Application by Highways England for an Order Granting Development Consent for the A303 Sparkford to Ilchester Dualling project

South Somerset District Council response - in relation to the Unilateral Undertaking submitted in respect of issues of bird strike

NOTES

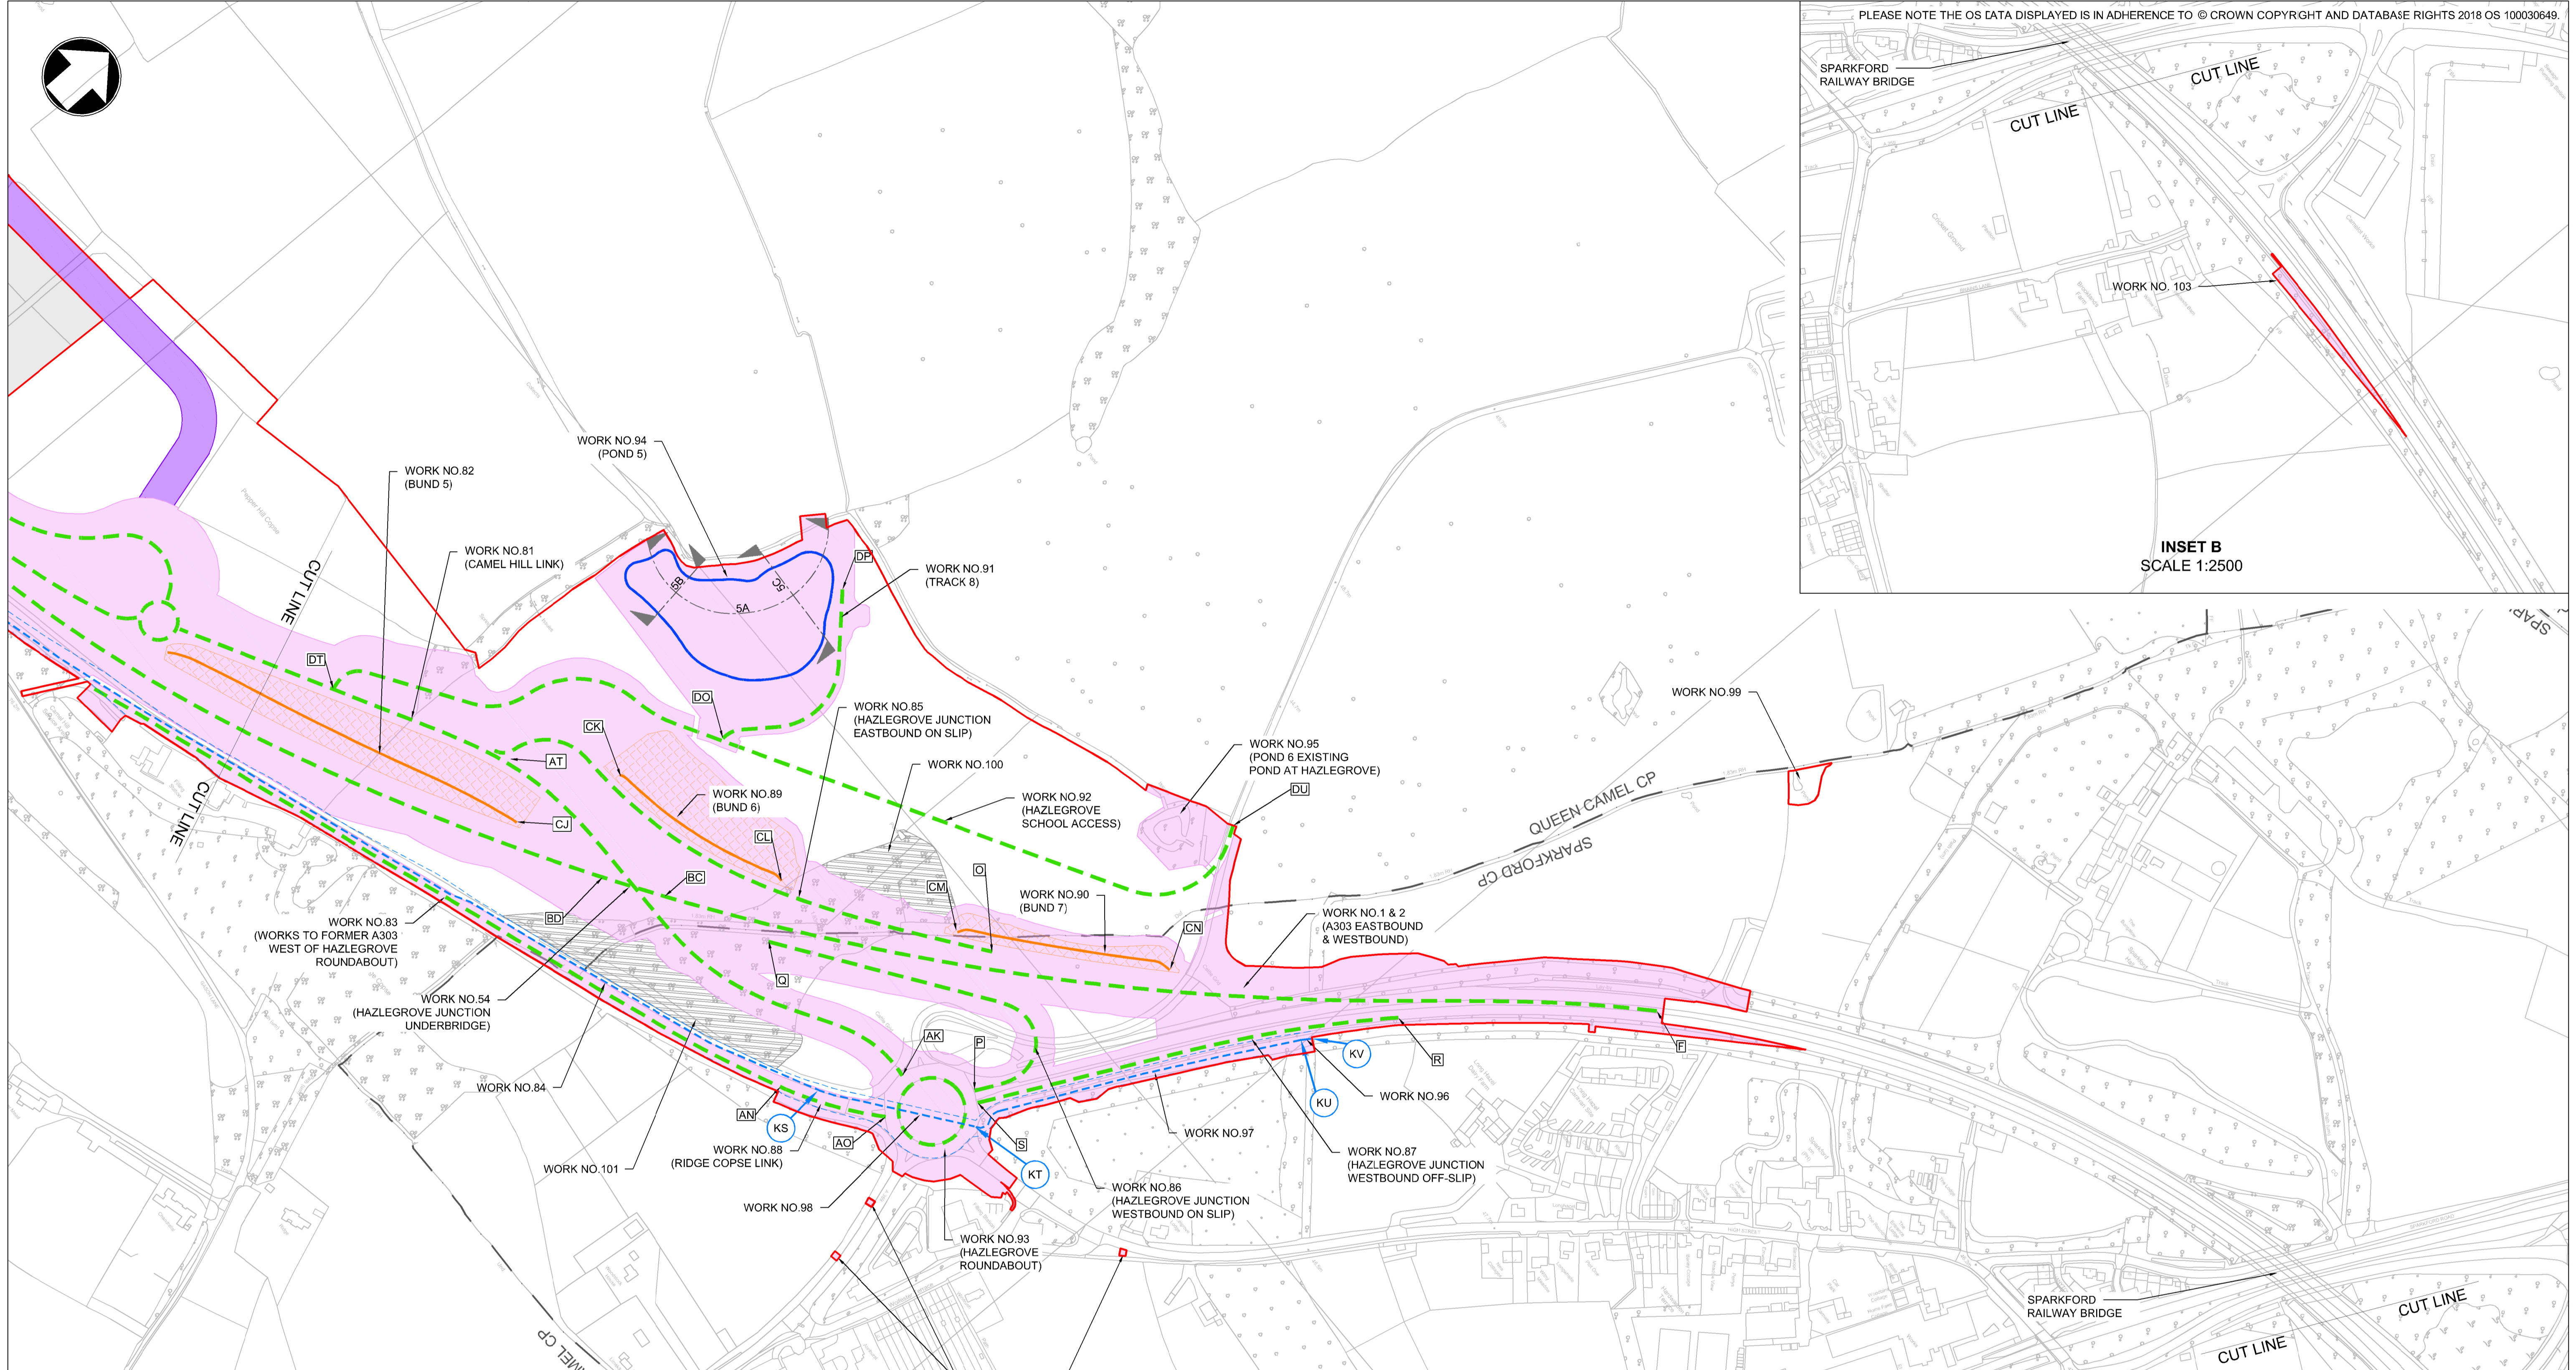
1. For the purposes of clarity, confirmation could be provided on the face of the UU that the Ponds will be within the continuous red line as shown on Plan 1 by amending the definition of the Ponds to refer to its location within the Site.

2. If there is any prospect of the final location of the Ponds will be outside of the continuous red line on Plan 1 (through the detailed design requirements or the process generally) then this must be addressed as it would appear that obligations in the UU may not be enforceable in that scenario.
